Re: Sirius Building - Tree numbers 50 and 51 – Request for further information.

It is noted that the NSW Department of Planning, Industry and Environment has requested further information regarding the proposed works and removal of the trees. Specifically, the following information is sought by the Department in respect of the trees and their proposed removal and replacement:

L-DA-012

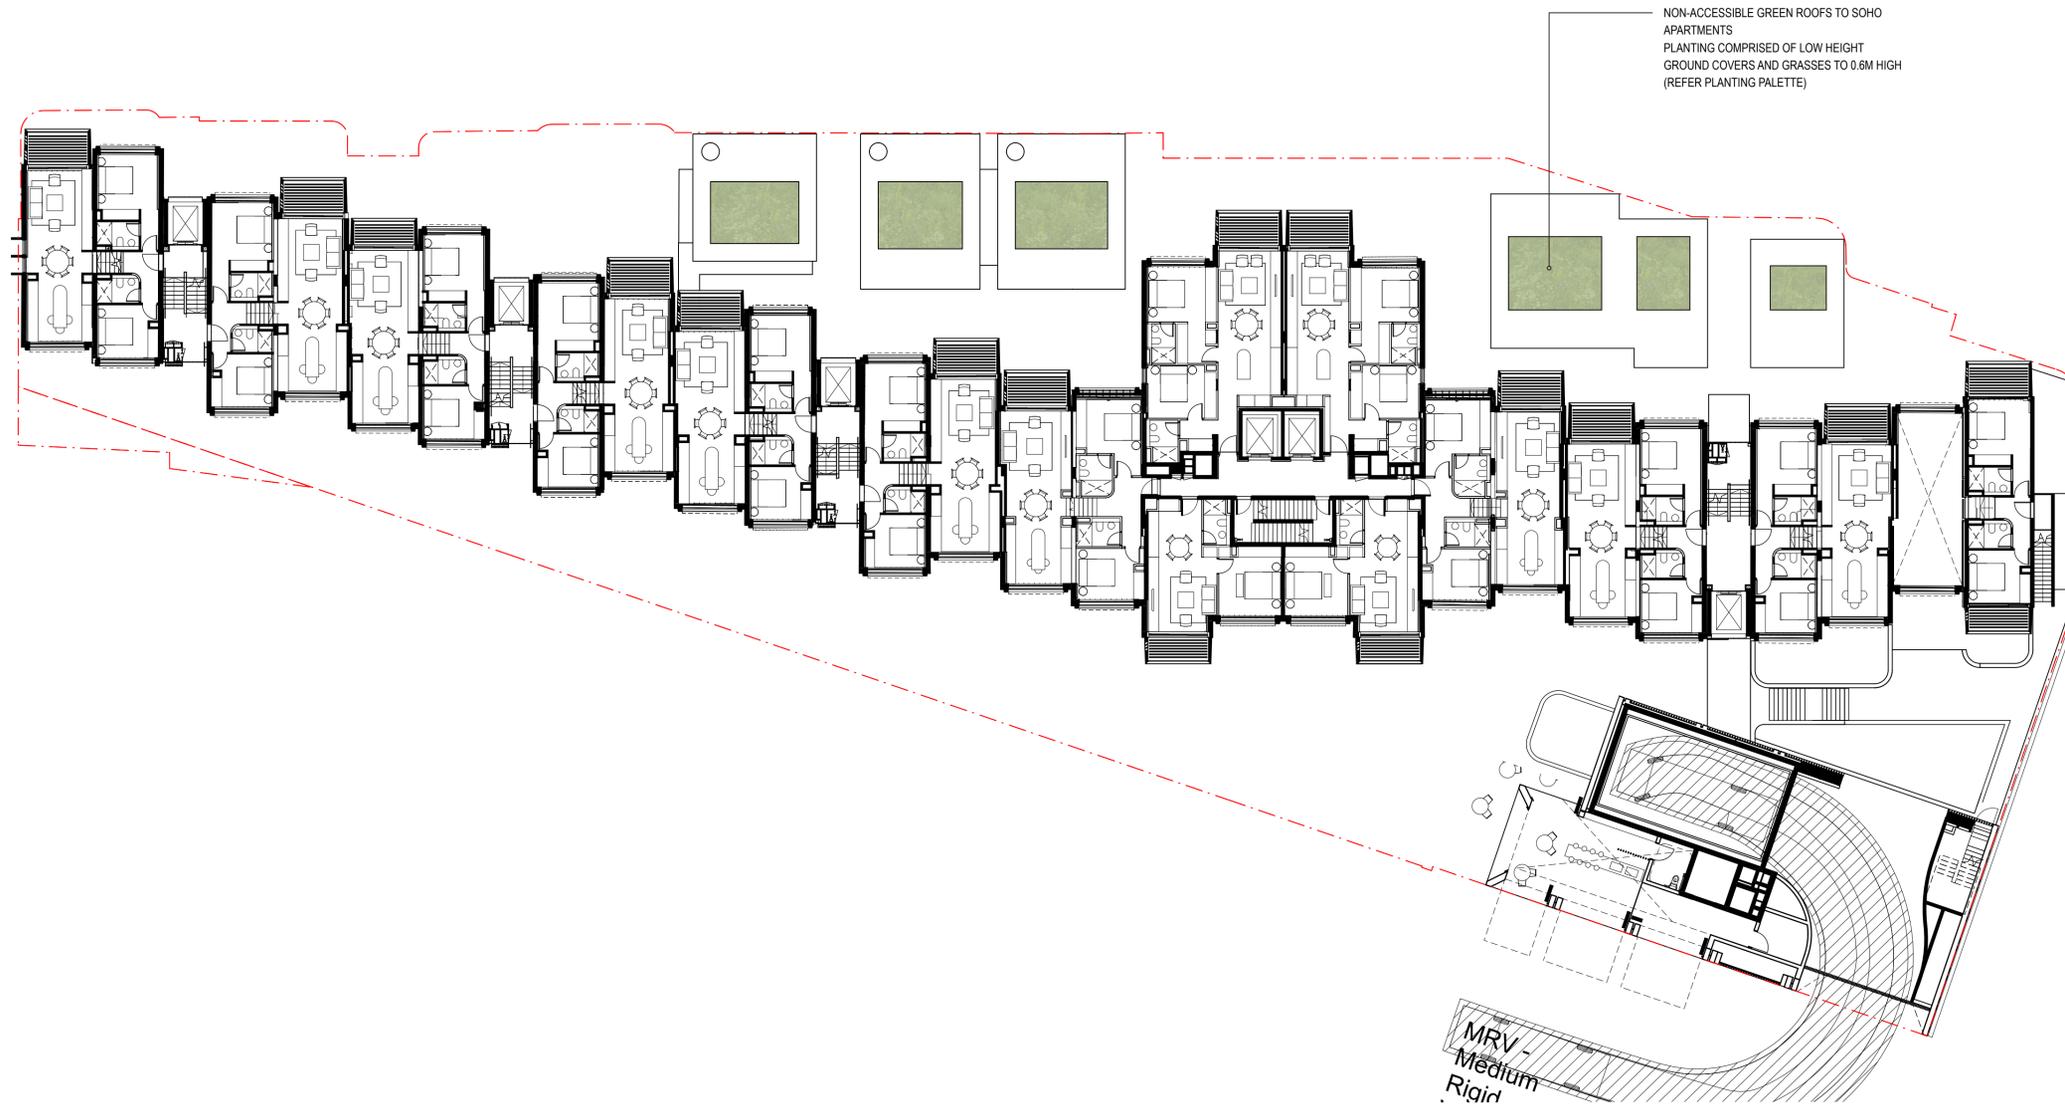
Clarify if the proposed four trees mitigates the proposed tree removal as a canopy cover lost to the proposal, will in time, be restored with better performing and more varied plantings

Clarify if the proposed tree planting will improve the mix of indigenous and native plantings improving biodiversity outcomes

The 4 proposed replacement trees will more than compensate for the removal of the 2 Plane Trees in time. The replacement species *Nyssa sylvatica* (Nyssa, Tupelo) is a deciduous species that can be expected to achieve mature heights of around 15 metres or more and canopy spreads of 8 to 10 metres.

The replacement plantings, together with the extensive other plantings proposed in the current landscape plans, will provide for an improved and diverse range of species.
